# GRADING AND EROSION CONTROL PLAN 208 CUNNINGHAM DRIVE

County Engineer/ECM Administrator: \_\_\_\_\_ Date: \_\_\_\_\_ PCD FILE NO. CDR242

GRADING AND EROSION CONTROL PLAN			
JOB NO.	FV21181	ORG. SUBM. DATE	12/22/2023
DWN:	JMP	CHKD:	DW
NAME:

**SPILLWAY CROSS SECTION**  
 N.T.S.

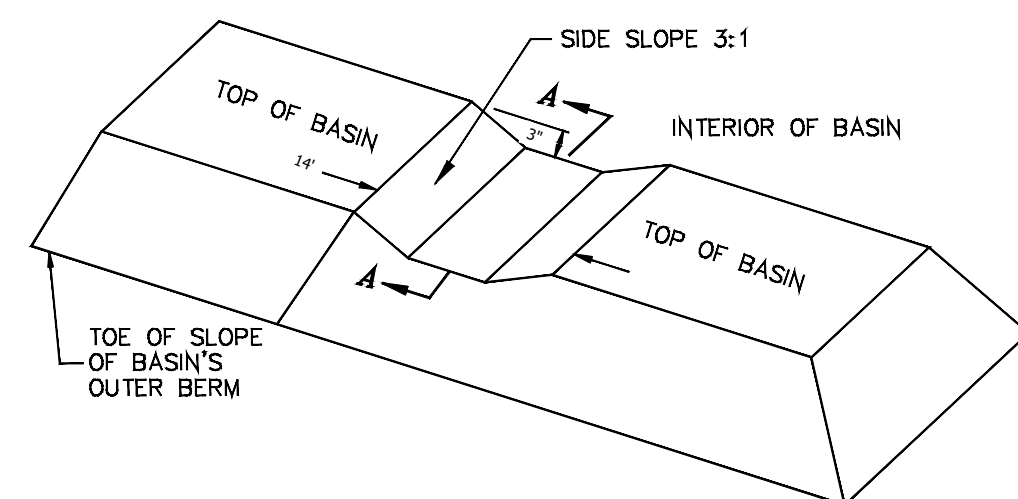
In the FDR, provide calcs for spillway that support these dimensions and that grass lined is acceptable.
